**FINAL DRAINAGE REPORT
FOR
SADDLEHORN RANCH – FILING 5 EARLY GRADING**

**August 17, 2023
Project No. 25142.07**

**El Paso County PCD File No.:
EGP226**

FILING 5 - DESIGN POINT SUMMARY

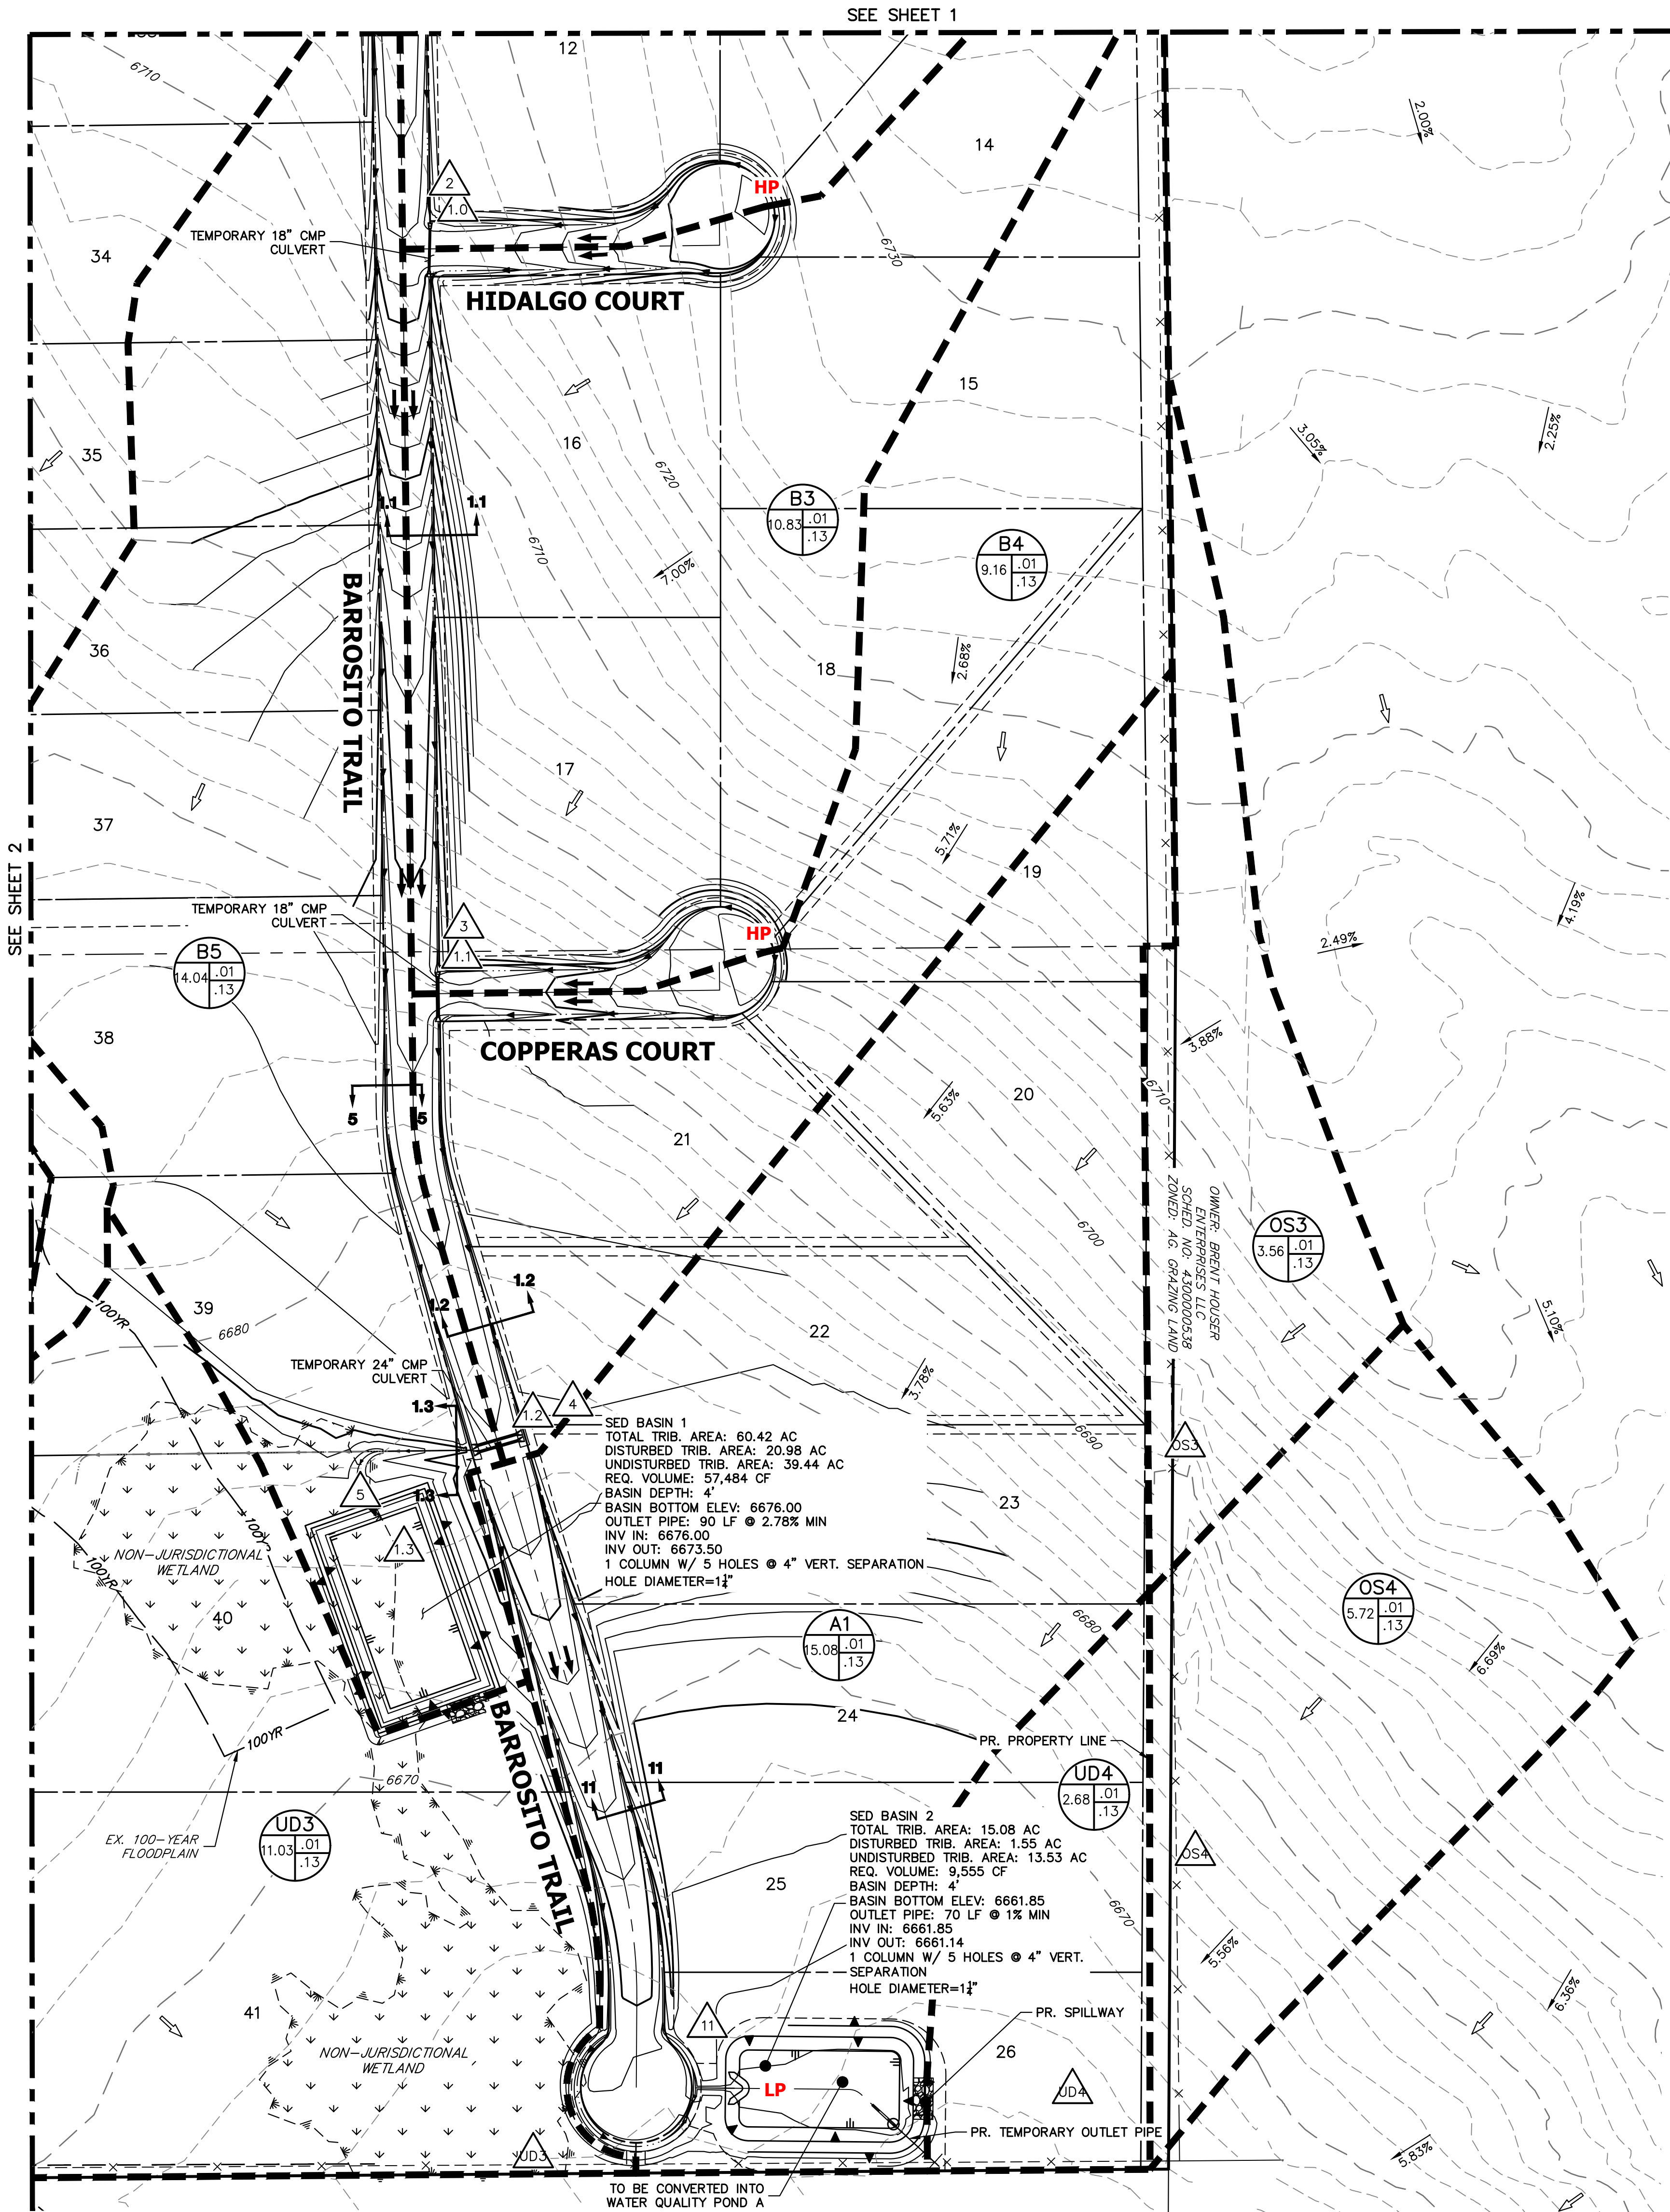
59.24 for Basins B1 to B5. Does this include OS1 & OS2? then include them in the discussion that OS1 & OS2 are also diverted to Sed Pond 1

Finish basin name
